From: [REDACTED]
To: [Planning Comments \(Shared Mailbox\)](#)
Cc: [REDACTED]
Subject: Objection to Application: 6/2024/0616/HOUSE - 41 Northaw Road East, Cuffley, EN6 4LU
Date: 30 April 2024 13:01:19
Attachments: [REDACTED]
Importance: High

RE: Planning Application: 6/2024/0616/HOUSE

Proposal
existing layouts
and elevations

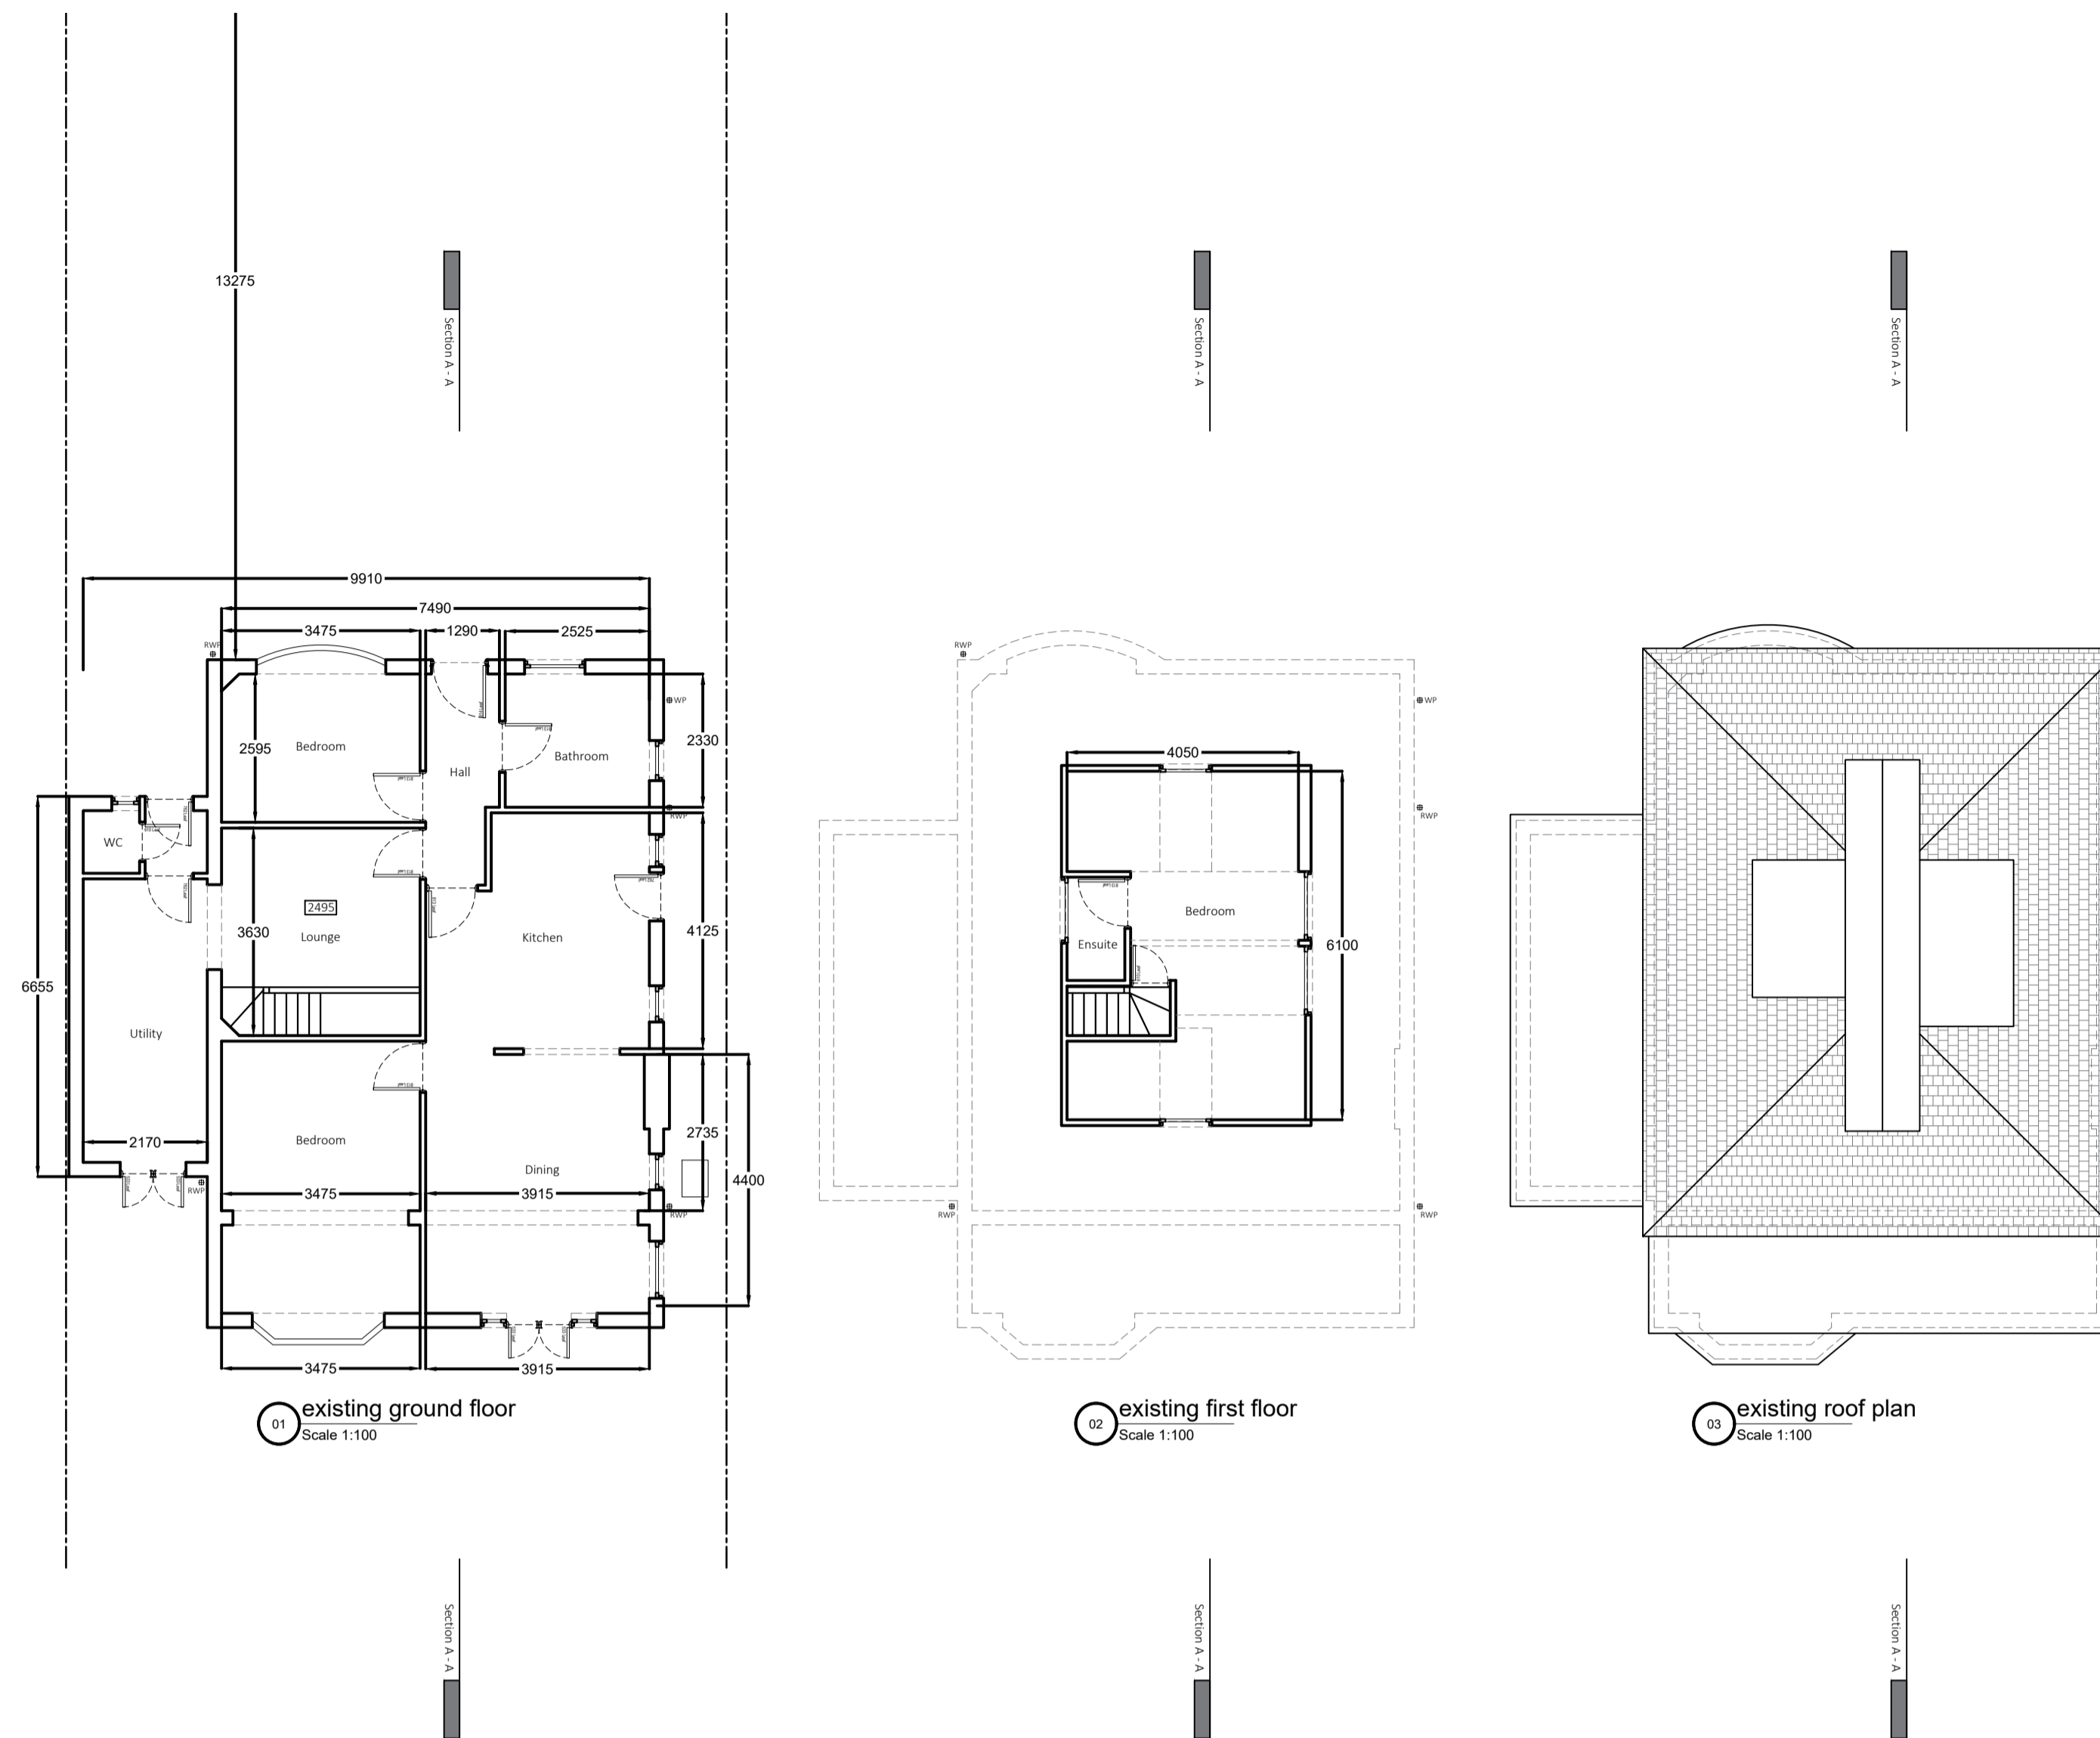
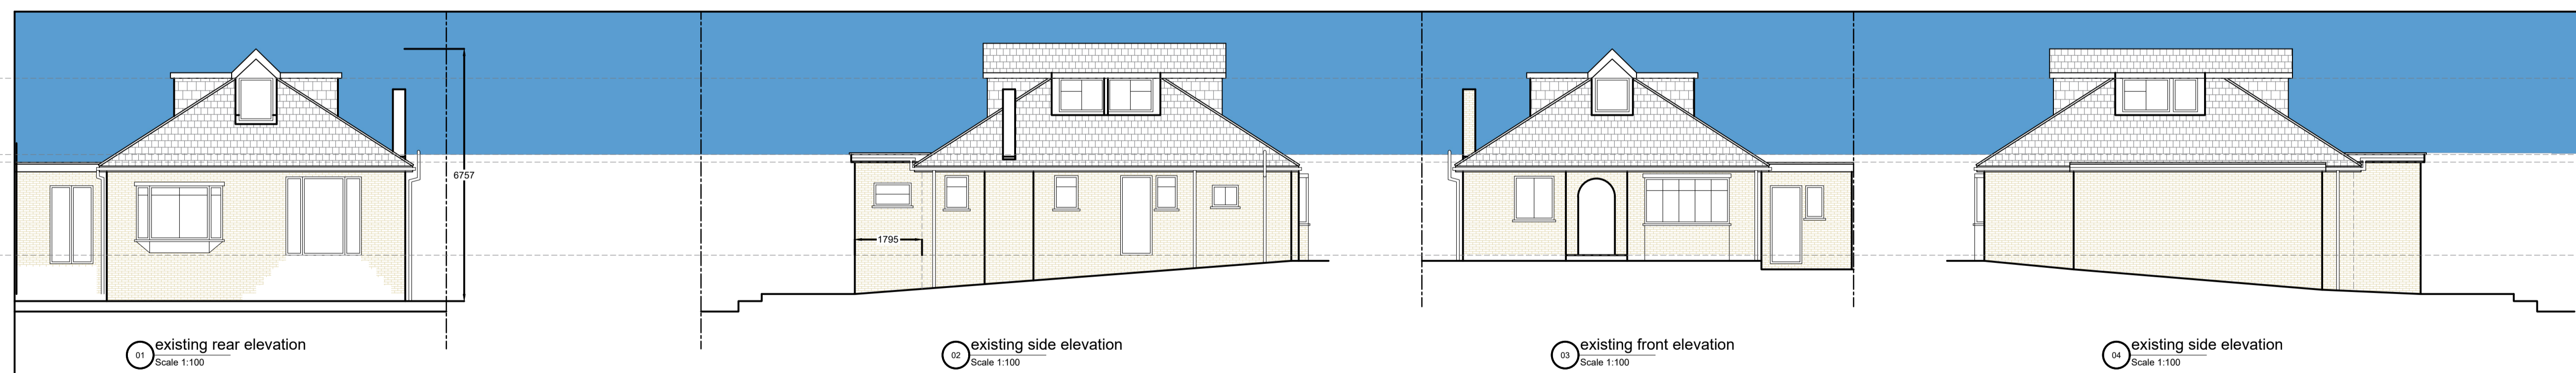
No.41 currently has space in front of and behind the room marked as Utility on the Existing Plan. This open space in front and behind the Utility provides important Right To Light to the main bedroom of No.43.

The current Utility has a door at the front and rear of the room, allowing access through the Utility to the rear of the property. It therefore serves as an access way.

Proposal proposed layouts and elevations

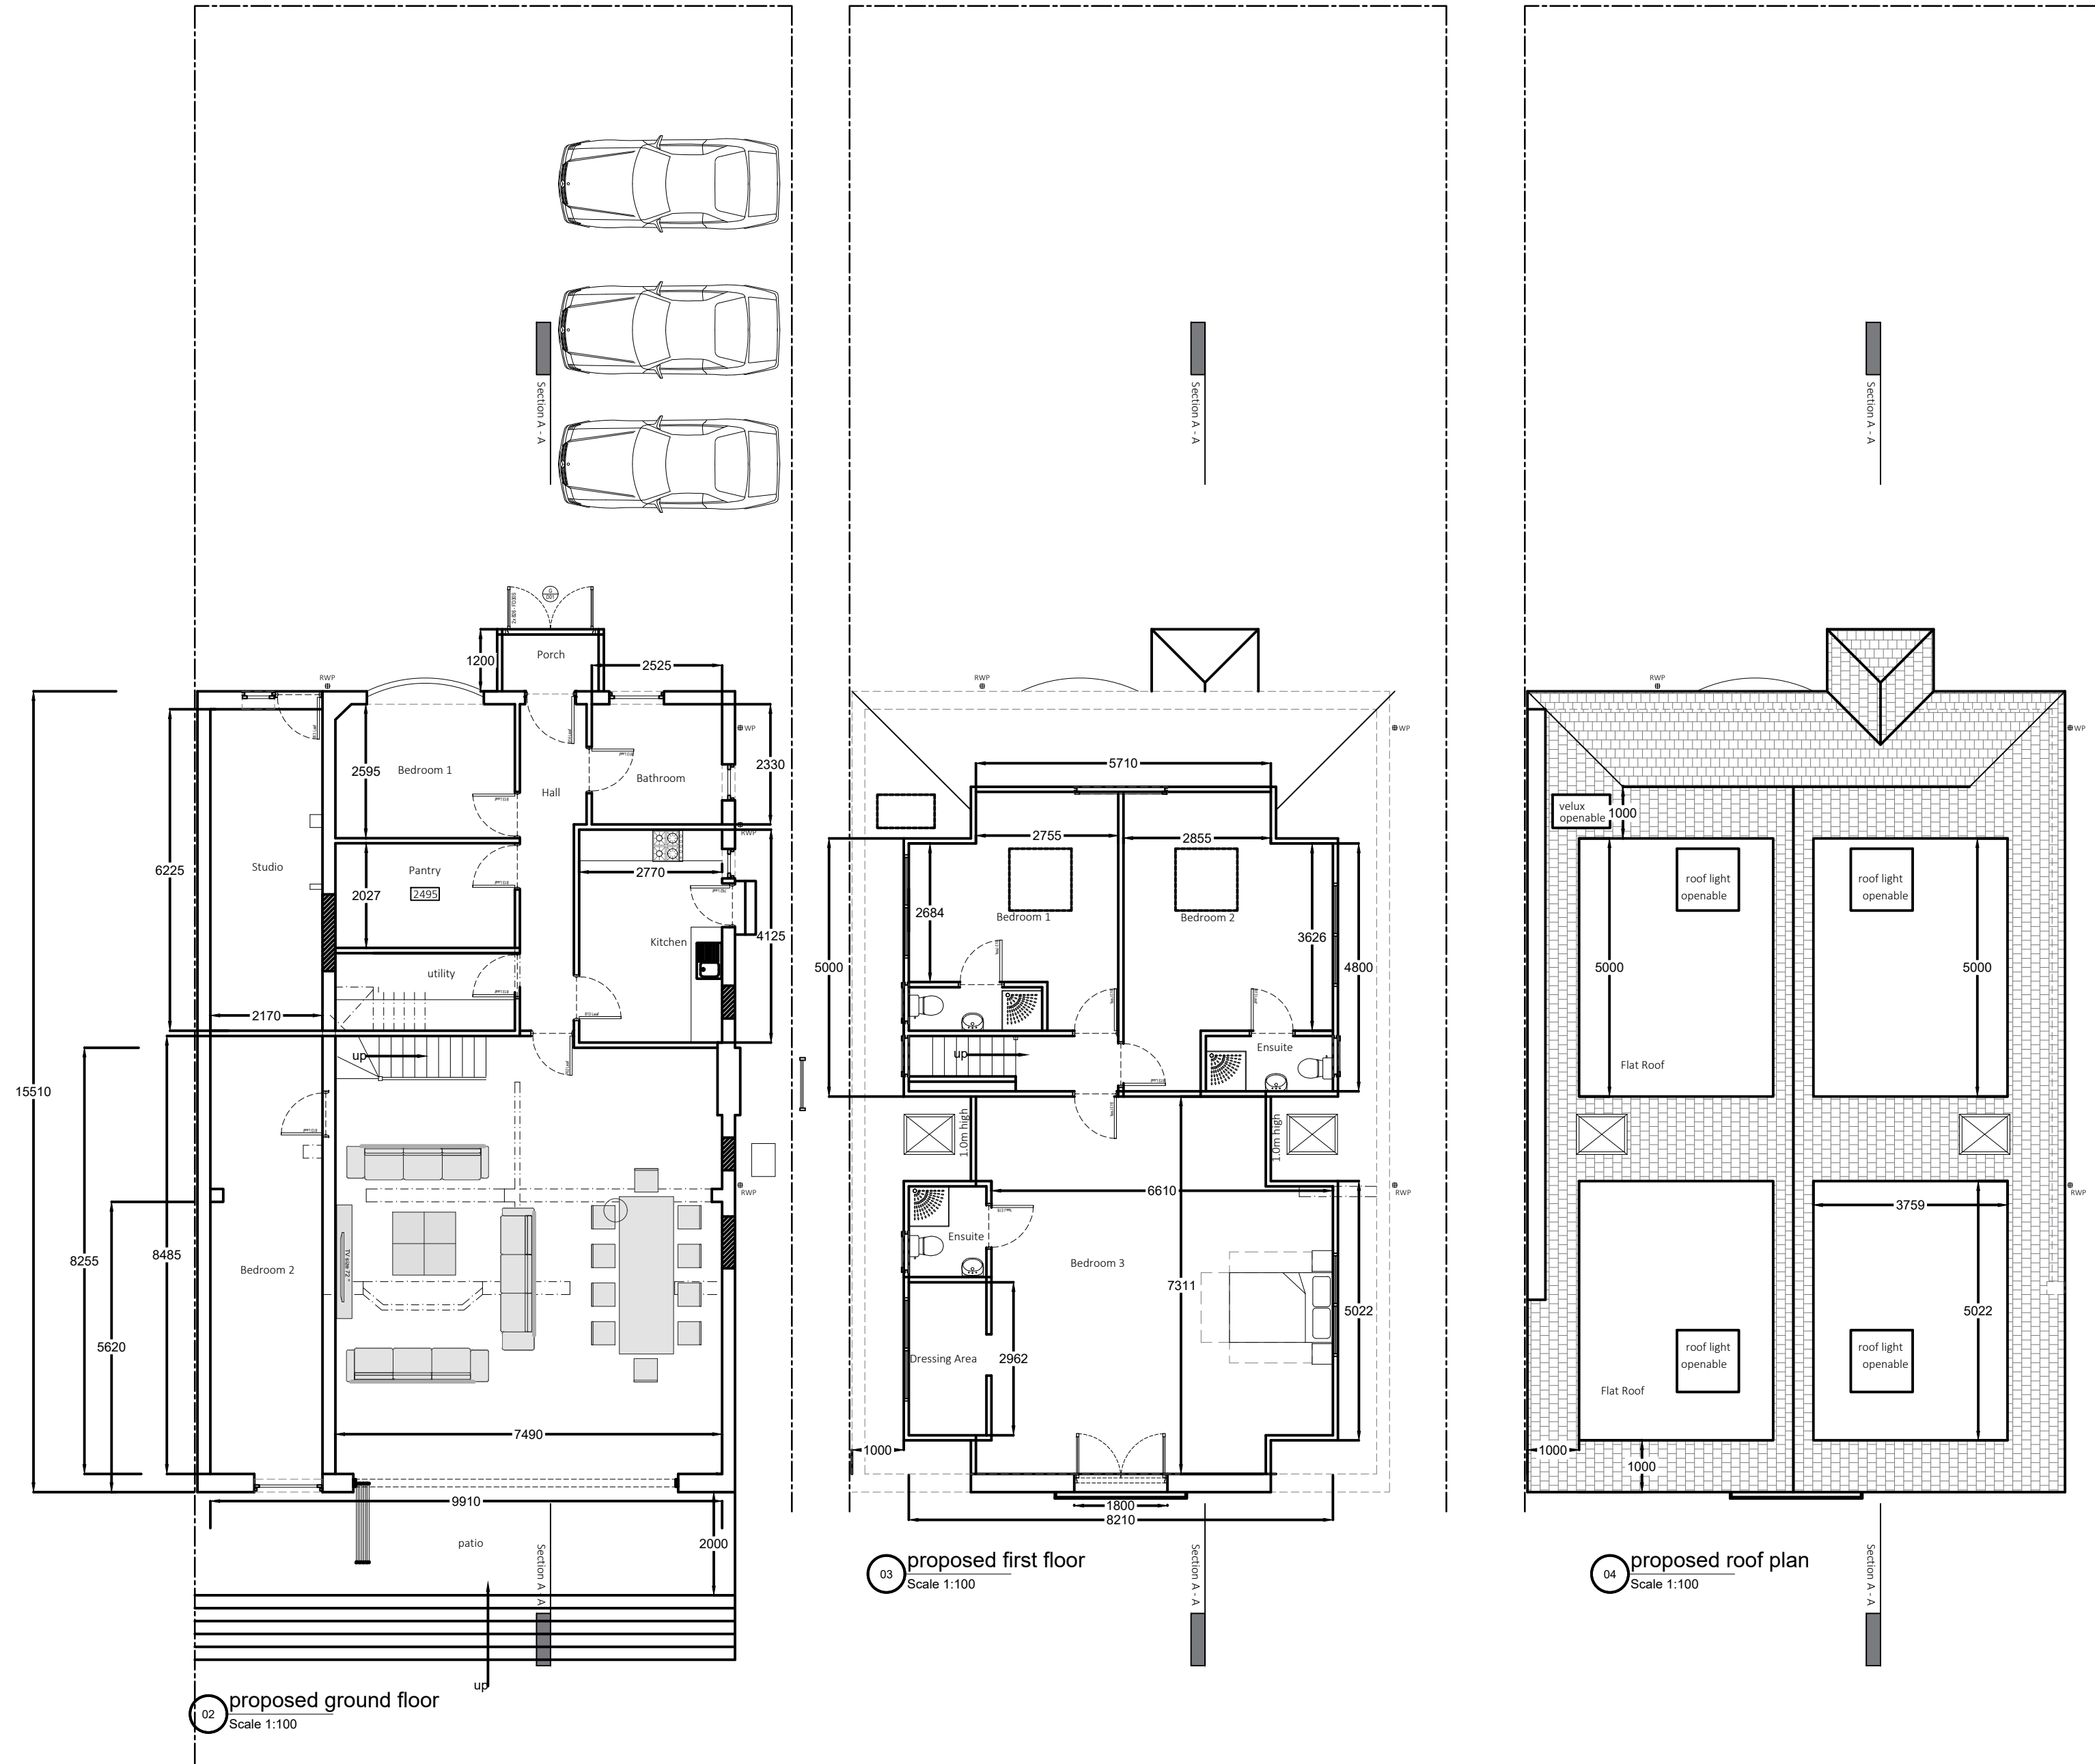
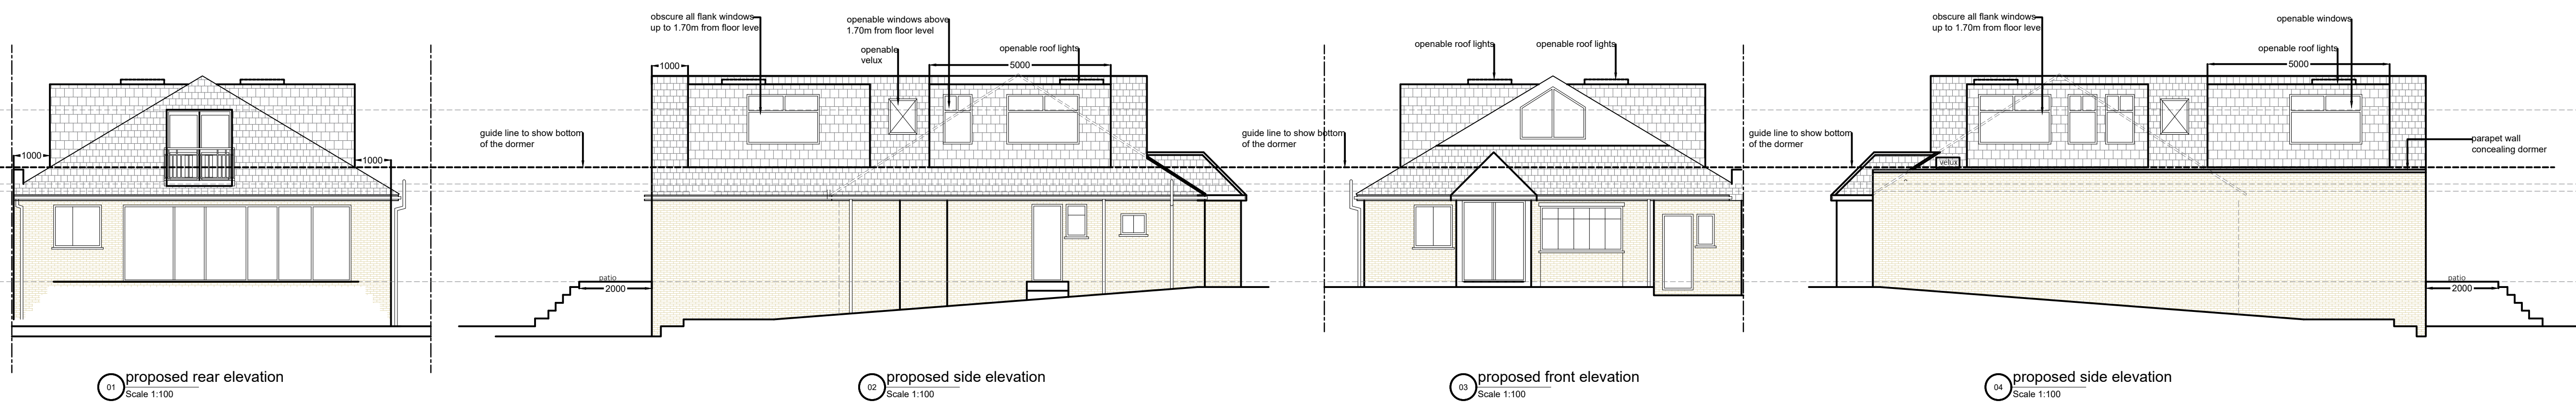
The proposed plan has the access route removed, the room(s) marked "Studio and Bedroom 2" extended to the front and rear, resulting in a loss of views and amenity to the front and rear.

Consequently, in accordance with D1(k) the rooms marked "**Studio and Bedroom 2**" at No.41:

- A. **may only be built on the existing footprint of the existing Utility;**
- B. access through the room must be maintained; and
- C. views on front and behind the room should be maintained.

Again, the Neighbourhood Plan is being breached. The open space in front of the room marked Utility should be retained. The proposed plan has the room(s) marked "Studio and Bedroom 2" extended to the front and rear.

This room(s) (**Studio and Bedroom 2**) **should not be brought forward to the front of the property**, instead it should retain its current position, and be set back.

Clearly the submitted plans contravene this. The points raised above are again relevant here. The rooms marked Studio and Bedroom 2 are extended and built along the entire boundary line with No.43. The spaces in front of the room currently marked Utility on the existing plans, should instead be retained. There will be a considerable loss of light to the principal bedroom of No.43 if building on the boundary is allowed.

An extension up to the boundary would result in a significant loss of light to the principal bedroom of No.43. Further, the roof and dormers being set close to the boundary will have the same impact as an entire second floor and will entirely block out light to the principal bedroom of No.43.

The dormers facing No.43 will be very close to the boundary line. This contravenes D1 (b) of the Cuffley Neighbourhood Plan.

These dormers must be scaled back, they should not be as close as they are to the boundary, in order to reduce the impact on the loss of light and privacy to No.43.

The plan requires the ridge height to be completely changed and raised, which is not in-keeping with adjacent properties.

The submitted plan is clearly in contravention of this. These rules are created to ensure that character of Cuffley is maintained, we should not simply ignore these rules. **The ridge height should not be raised.**

The submitted plan by No.41 is a wrap around extension. It is on three sides of the property, involves a significantly increased roof size, involves large Dormers, and changes to pitch, elevation and size.

The complicated and expanded roof, the front to back side extension, the rear extension - all of this **will result in the original property being "lost" in the extension which is in contravention of the rules.**

The application drawing does not show how No.41 relates to adjoining properties. It fails to show elevations and heights. So it is not possible judge the impact of the raised patio on immediate neighbours ie the potential loss of privacy. As well as water run off.

This will result in a loss of privacy to local neighbouring gardens. Instead, this should be changed to a regular window.

This also appears to be in **Breach of the 45 Degree Rule and 12m protected zone of privacy.**

Clearly the raised patio, the Juliet Balcony these are both in contravention of this requirement on the Neighbourhood Plan. **The raised patio and the Juliet Balcony should not be allowed.**

The side dormer windows are shown as obscured glass to 1.7m.

The proposed dormer windows seem avoidable and therefore **there should not be any windows in the dormers on the sides of the property** that overlook neighbours.

Where the applicant proves that a window meets the high threshold of being **unavoidable**, at the very least (as per a previous enforcement concerning No.45 Northaw Road East, ENF/2016/0043), **all side-elevation windows should be:**

A. **raised to 1.8m obscured glass; and**

B. **non-openable.**

The proposed porch appears to bring forward the front elevation. This **should not be allowed and the current elevation of the building maintained.** This change further takes the house out of falling in line with its neighbouring properties.
